PLANNING PERMISSION

APPLICATION NO: 3/2020/0583
DECISION DATE: 07 September 2020
DATE RECEIVED: 23/07/2020

DEVELOPMENT PROPOSED: Proposed demolition of existing lean-to porch to be replaced by proposed rear and side extension. Resubmission of application 3/2020/0297.

AT: 49 Downham Road Chatburn BB7 4AU

3 PROPOSED ROOF PLAN
1 : 100

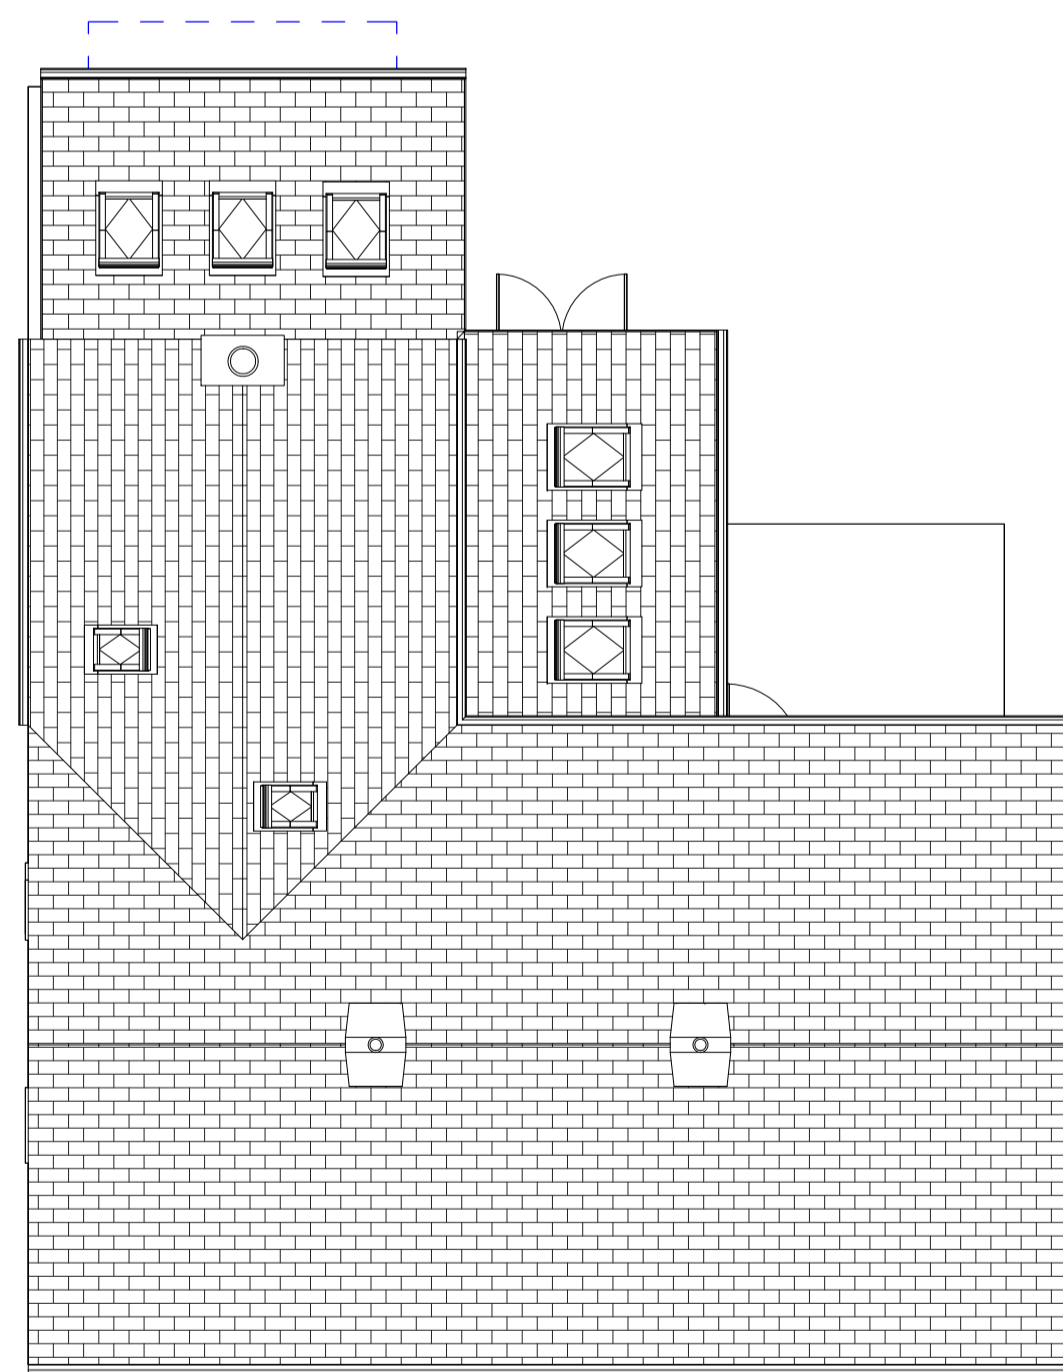
4. Notwithstanding the details shown upon the approved plans, the proposed roof lights shall be of the Conservation Type, recessed with a flush fitting, details of which shall be submitted to and approved in writing by the Local Planning Authority prior to installation. The development shall be carried out in strict accordance with the approved details.
